Engineers Comments Regarding Surface Water Drainage

Application Reference:	Y/8/26/DOC	Reviewer Reference:	ADC/EXT5/AF
Planning Officer:	Hebe Smith	Date of Review:	15/05/2026
Site Name:	Tyrolean Lodge Main Road Yapton BN18 0EA		
Application Description:	Approval of details reserved by condition under Y/32/23/PL relating to condition 8- Surface Water Drainage.		
Assessment Number:	4

DRAWING NO: 0007_500
TITLE: DRAINAGE PLAN AND DETAILS

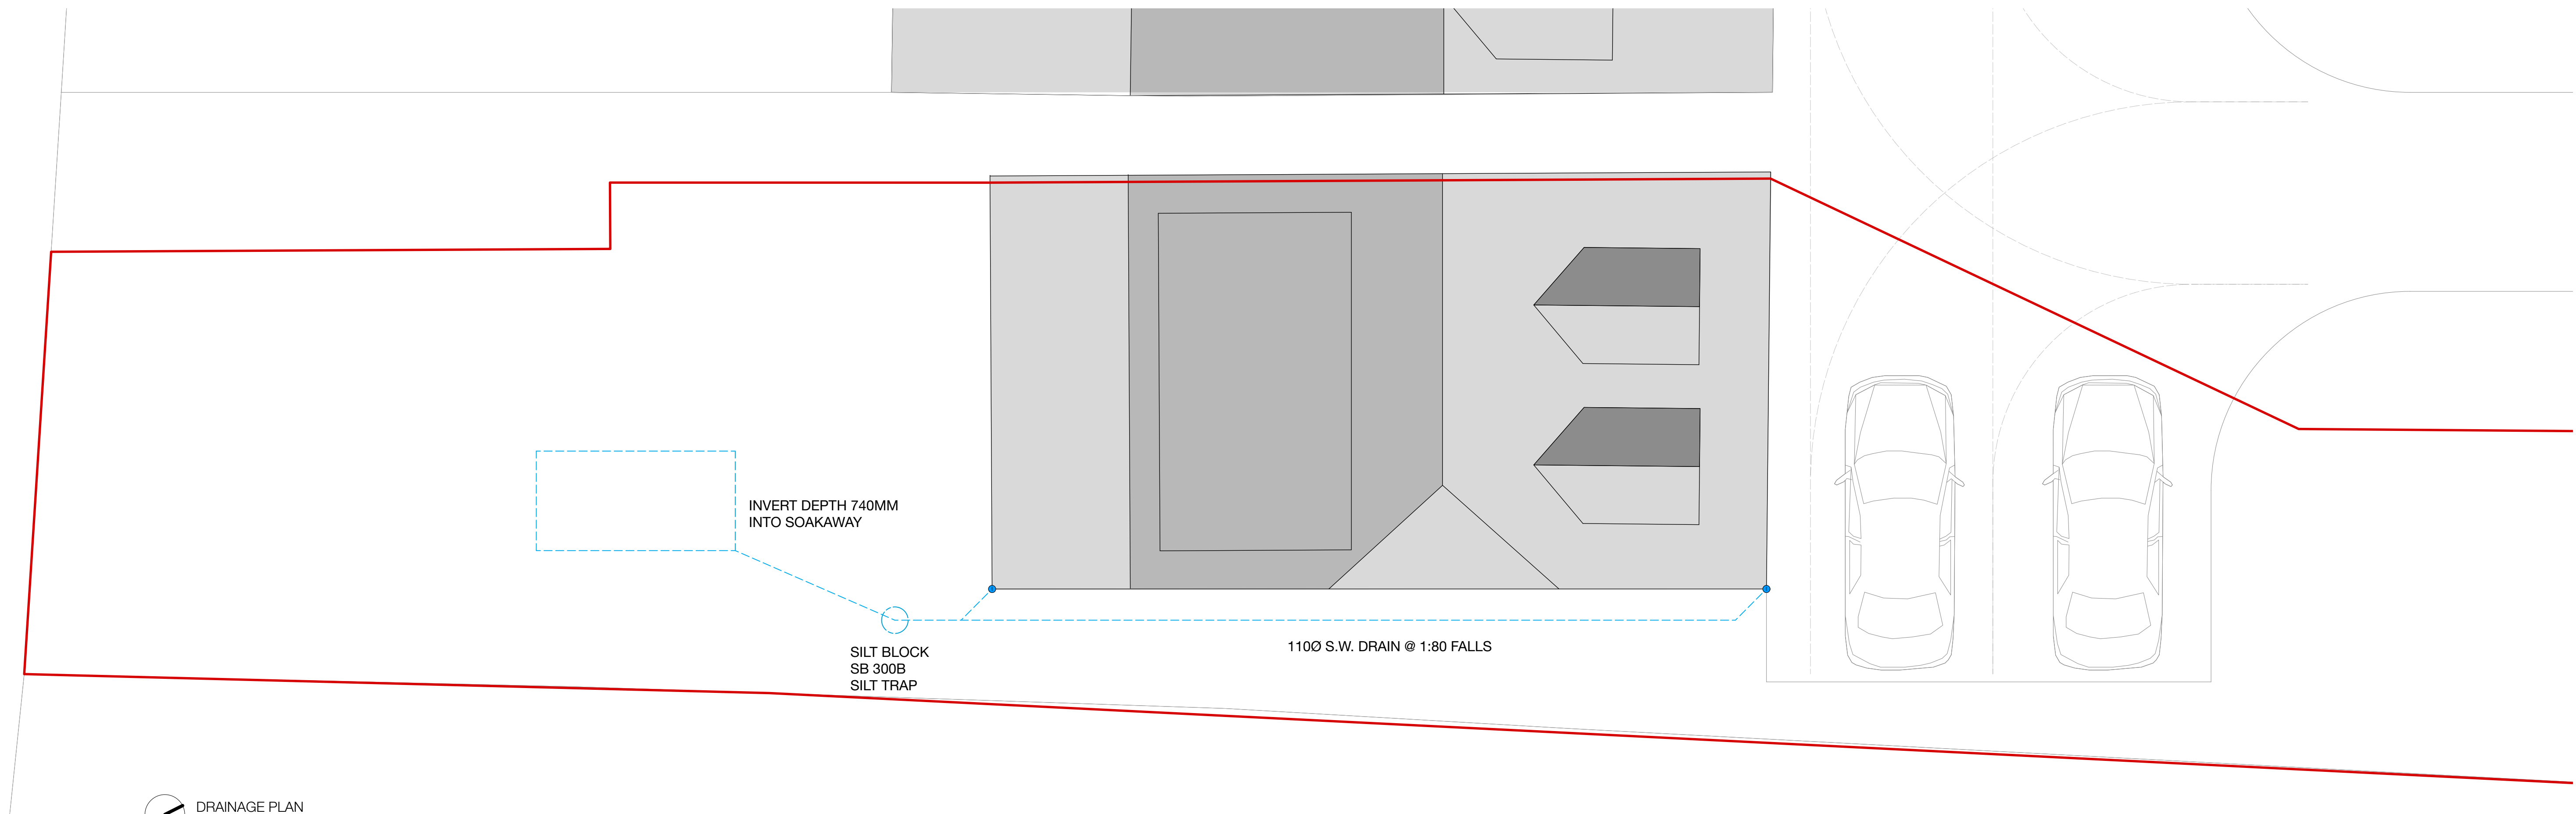
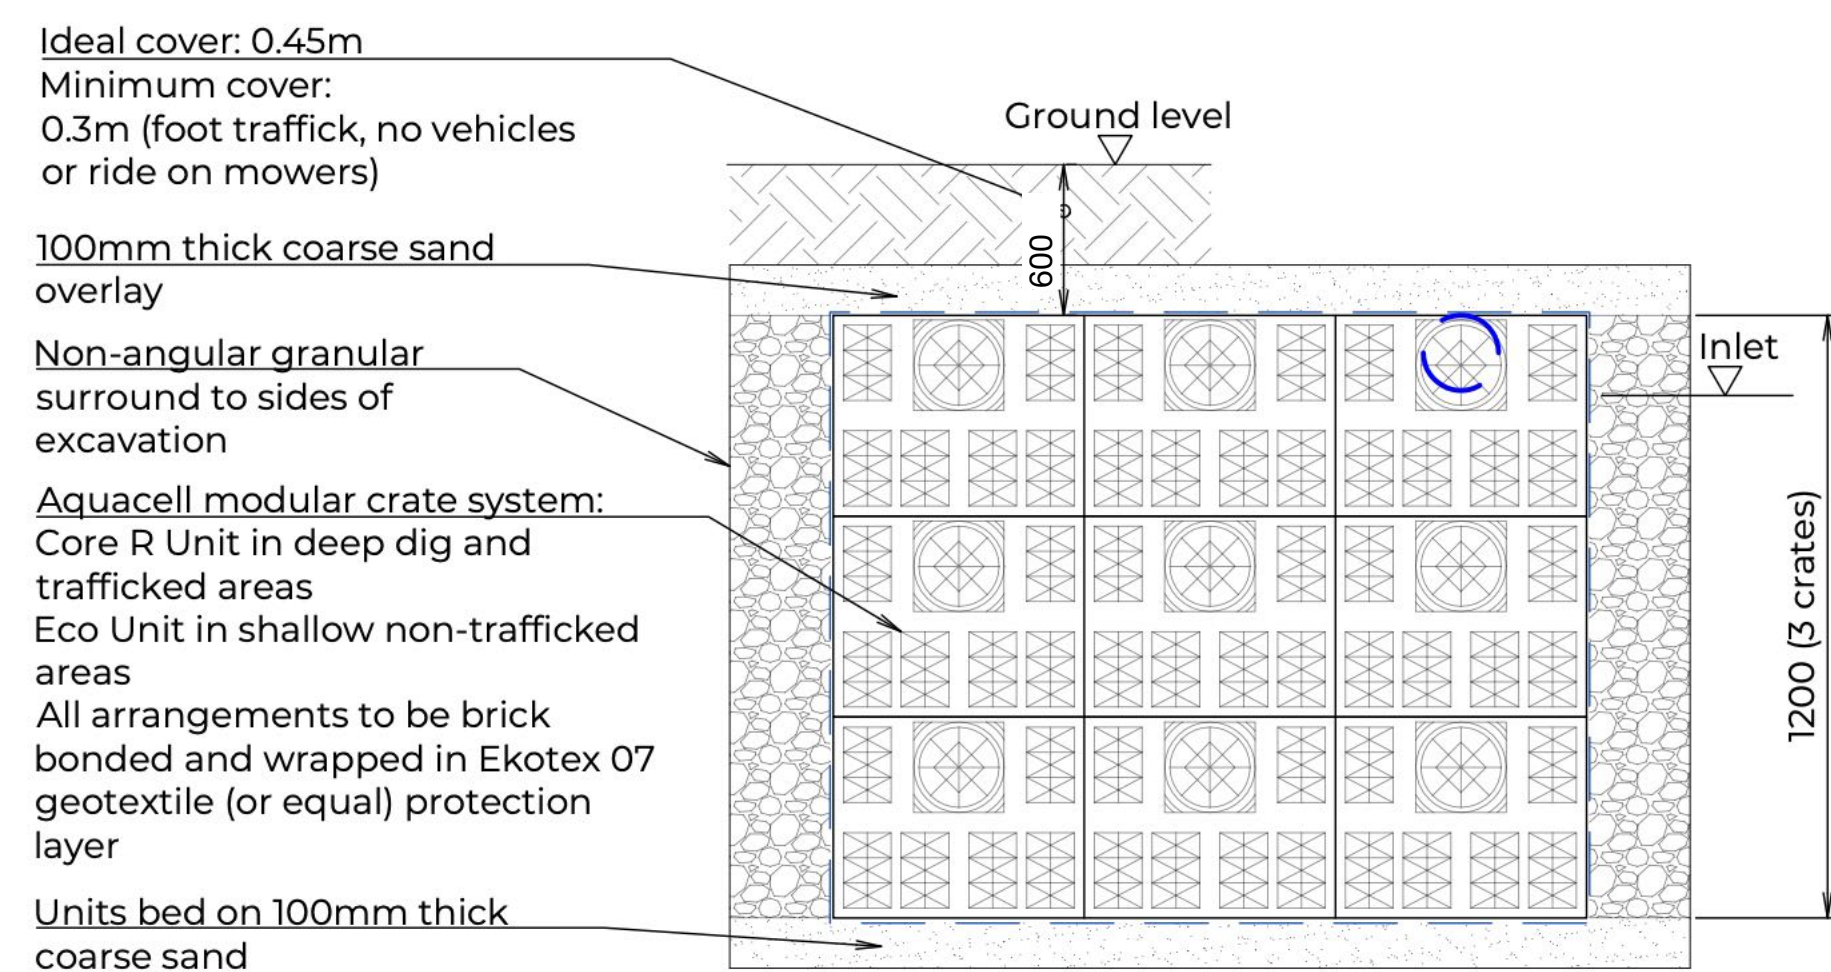
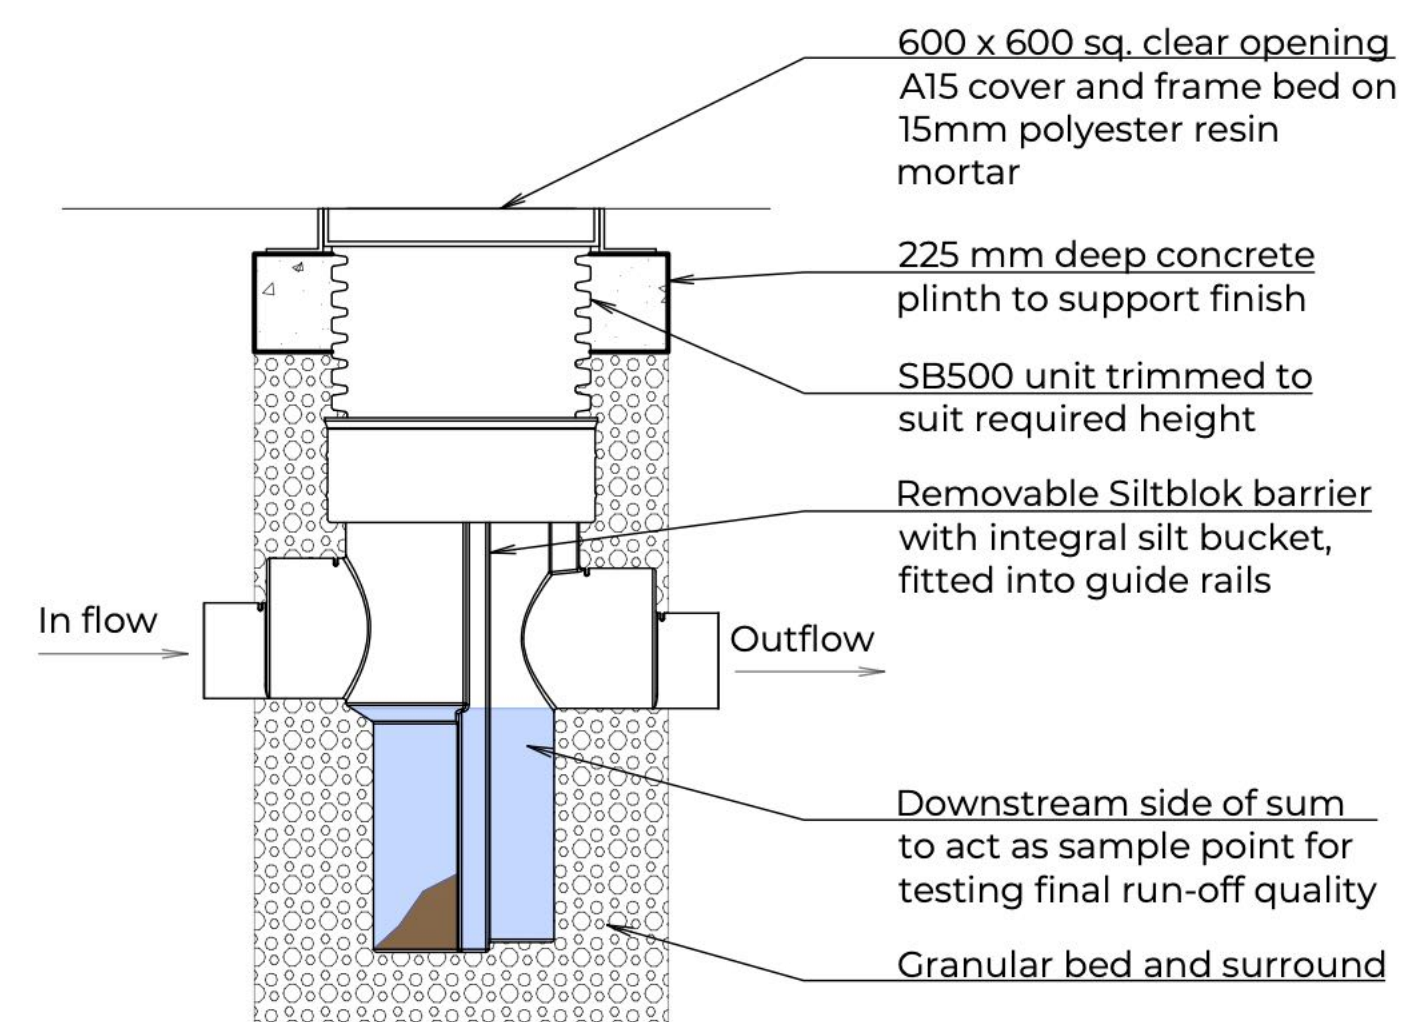
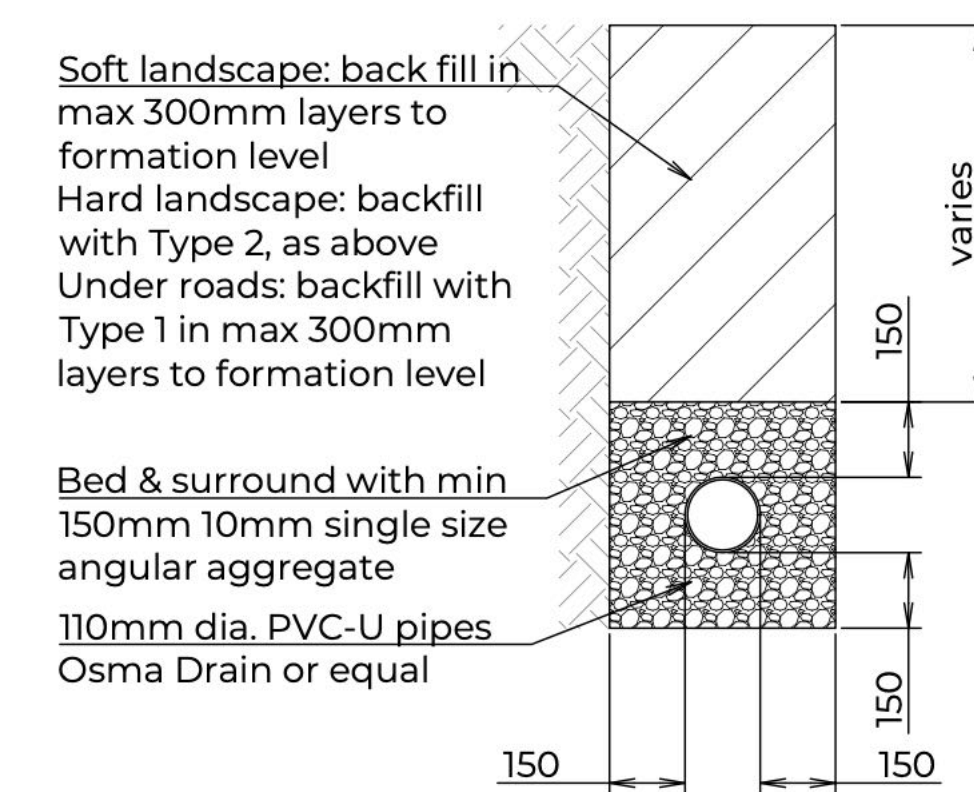
depth of the percolation test should be confirmed to be similar to the soakaway design. Designer Response 17/04/2026 It is confirmed that the BRE 365 method was adopted and that the depth of the test pit was similar to that of the proposed soakaway depth				
3.	The groundwater monitoring provided appears to show a highest GW level of 3.25m bgl but this is not shown on a soakaway design drawing. A minimum of 1m vertical distance must be maintained above the high winter groundwater level. Designer Response 17/04/2026 Peak GW level appeared at 3.25m below ground level. The base of the soakaway is shown at 1.74m below ground level giving a vertical distance between them of 1.51m	Comment closed			
4.	A Drainage Layout Plan and Construction Details should be provided suitable for	Comment closed.

RIBA Stage 4 Technical Design Designer Response 17/04/2026 Site plan attached showing surface water drainage layout and construction details.				
5.	No calculations are provided for extreme rainfall. See guidance on Arun DC webpages. Designer Response 17/04/2026 Revised calculations attached which take into account extreme rainfall.	The calculations do not include the design storm which is the 1% AEP plus 45% climate change allowance. This was noted to be required in comments made at planning stage.	The recalculation based on 1% AEP plus 45% climate change allowance (attached)	Comment Closed.

7.	No assessment of water quality mitigation is provided	Mitigation is acceptable, comment closed.

8.	A maintenance plan should be included Designer Response 17/04/2026 The system is very simple with only two rainwater pipes discharging into trapped gullies and on into single length of 110mm underground surface water pipe which then goes on through a Turtle Enviro Silt Block 500. The trapped gullies will be checked on a regular basis and cleaned if necessary. The recommendations for the silt block is that it is checked and cleaned annually.	A short statement summarising the maintenance requirements with the product literature attached can be submitted and provided to the homeowner.	I have been in touch with Turtle Enviro technical team and they inform me that there are no specific maintenance requirements as each site will be different. Their view was that as the run off area from this site is small and the areas concerned are essentially smooth there would be a minimal amount of silt entering the system. It was suggested that after a period of sustained rainfall the silt trap is inspected and then monitored on a	The explanation is acceptable. Comment Closed.

Designer Response 17/04/2026 Any water entering the system will only be the run-off from the slate roof. Leaf guards are to be installed at the gutter outlets to prevent contamination from any falling leaves. The downpipes discharge into trapped gullies and then into the 110mm stormwater pipe. This pipe discharges into a silt trap which will remove any silt before carrying on into the soakaway

monthly basis for the first winter. Given the site conditions an annual clean of the trap and filter should be more than adequate. Using this system there should be almost zero silt entering the soakaway. I will be the homeowner and so have all the information to hand		
--	--	--	--	--	--
